CITY OF ALBUQUERQUE

**RE: Monte Vista Elementary School
McMahon and Unser Blvd NW
Grading and Drainage Plan
Engineer's Stamp Date: 1/7/2022
Hydrology File: A11D011I**

Based upon the information provided in your submittal received 1/12/2022, the Grading & Drainage Plan is **not** approved for Building Permit. The following comments need to be addressed for approval of the above referenced project:

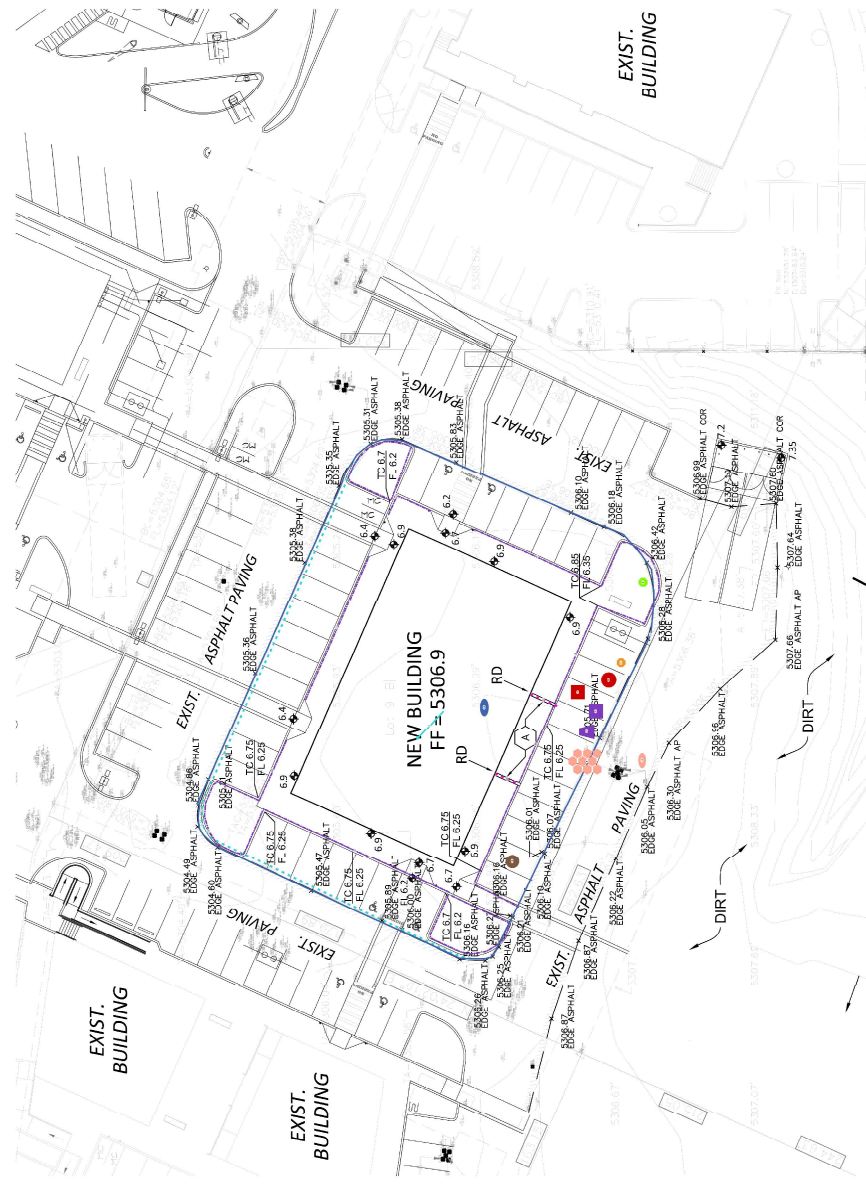
1. Please ensure this matches the master amended DMP and show where flow ends up ultimately.
2. Show how this meets the allowed flow from the amended DMP.

- a. E.g. basin G on DMP says 4.1 cfs/acre is planned. How does that compare to your proposed flow? Please show this information.
3. Historic flows are not allowed. Please state this adheres to DMP and state how.

4. Based on the DMP, this basin is supposed to drain to the north overall.
5. Please show if this site crosses other basins in the DMP and how the site will be split accordingly.

6. Show proposed flowline. Is the edge of asphalt proposed or existing?
 - a. It is unclear.
7. It is difficult to determine what is proposed vs existing on the plans. Please clearly delineate existing vs. proposed infrastructure and grading including new asphalt and impervious areas.

- a. Where do you tie into existing infrastructure/asphalt etc..? matching grades etc...
8. Where is the water quality volume being proposed?
- 9.
